CITY OF ALBUQUERQUE

**Re: Ascension Subdivision – 8814 Horizon
Erosion and Sediment Control Plan
Engineer's Stamp Date 10/22/2019 (B17E006)**

Based upon the information provided in your submittal received 12/19/2019, the above referenced plan cannot be approved by the City until the following concerns are addressed.

BEST MANAGEMENT PRACTICES

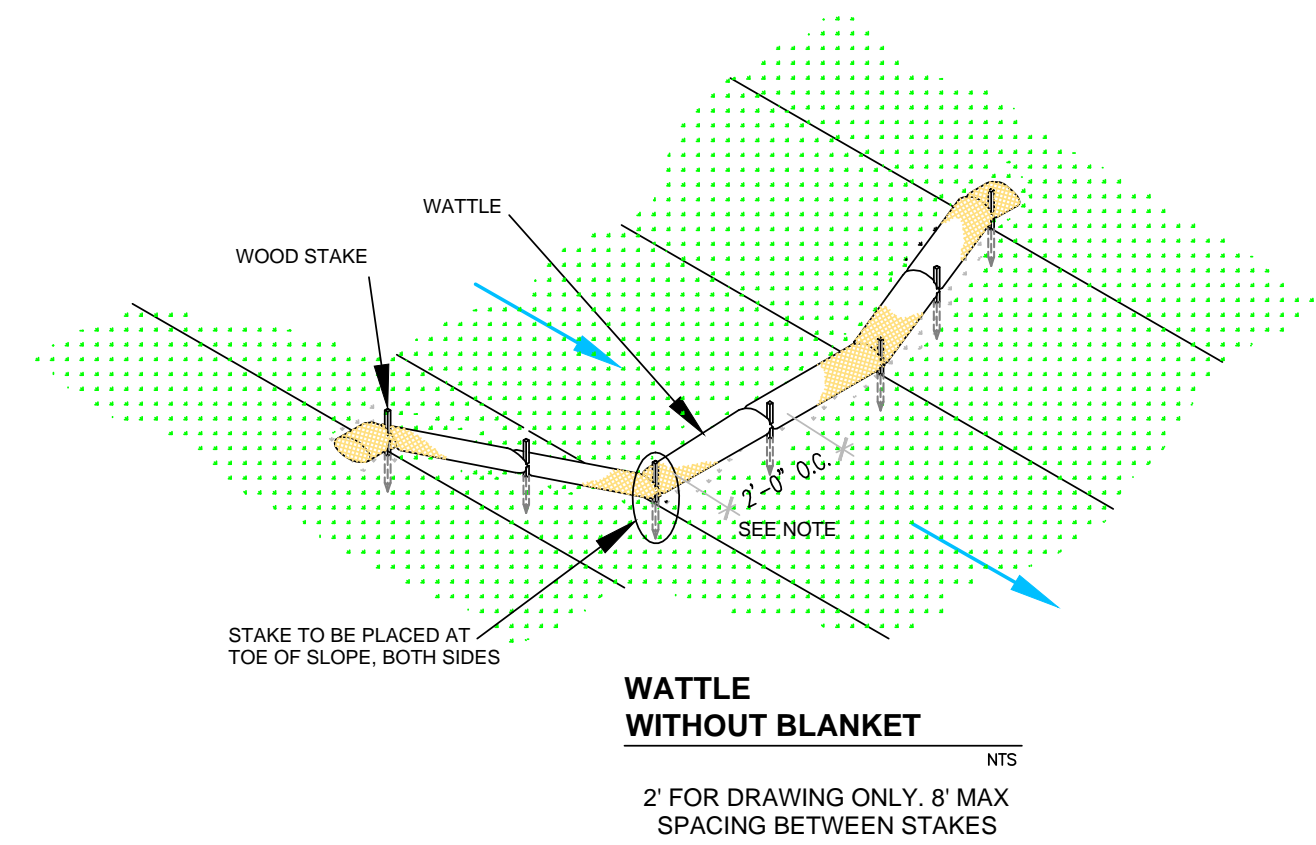
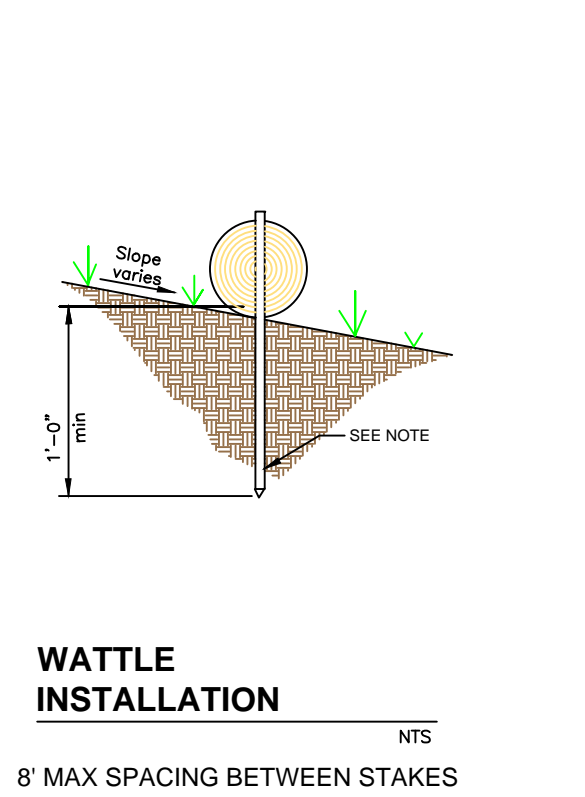
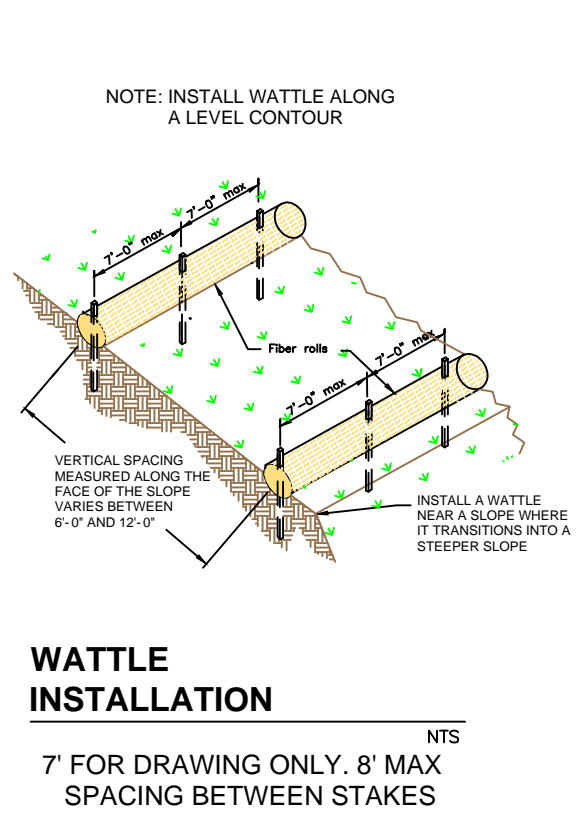
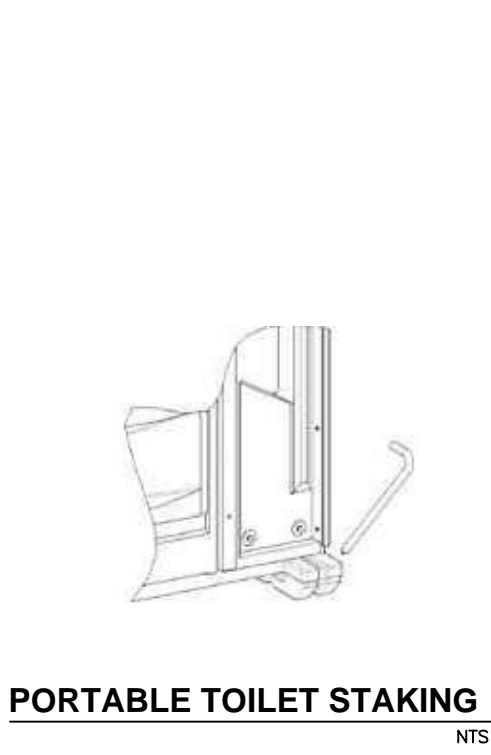
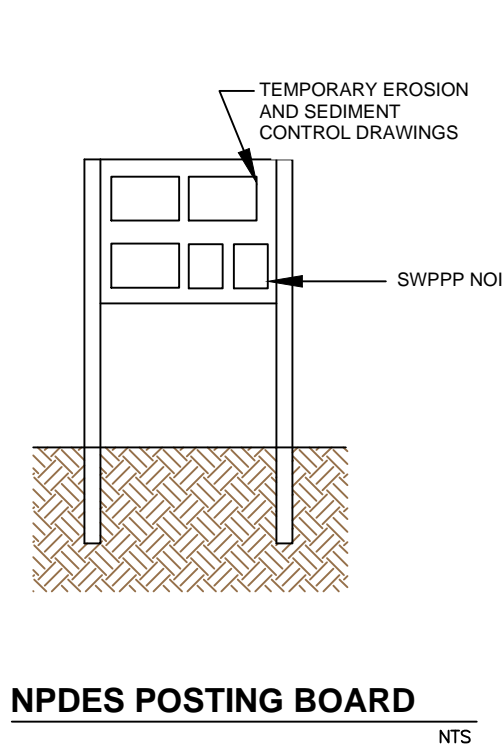
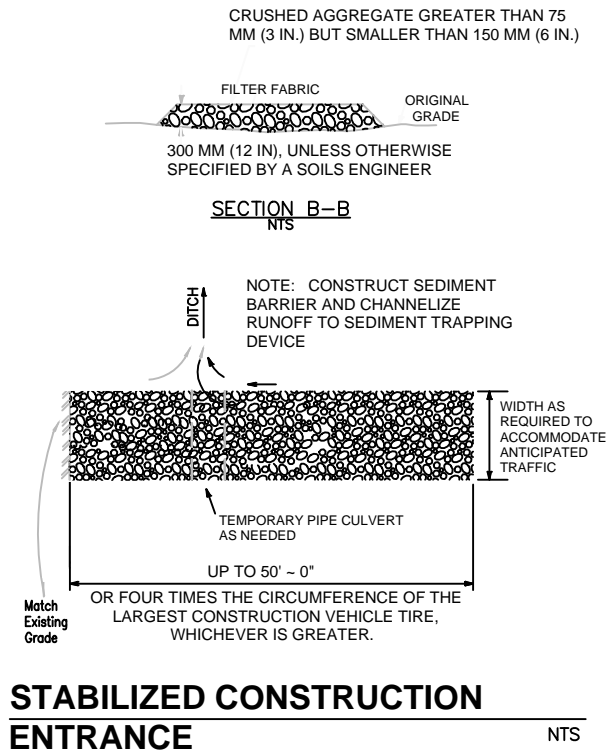
6. Please add the following standard notes and modify or delete conflicting notes on sheets 3 and 4.
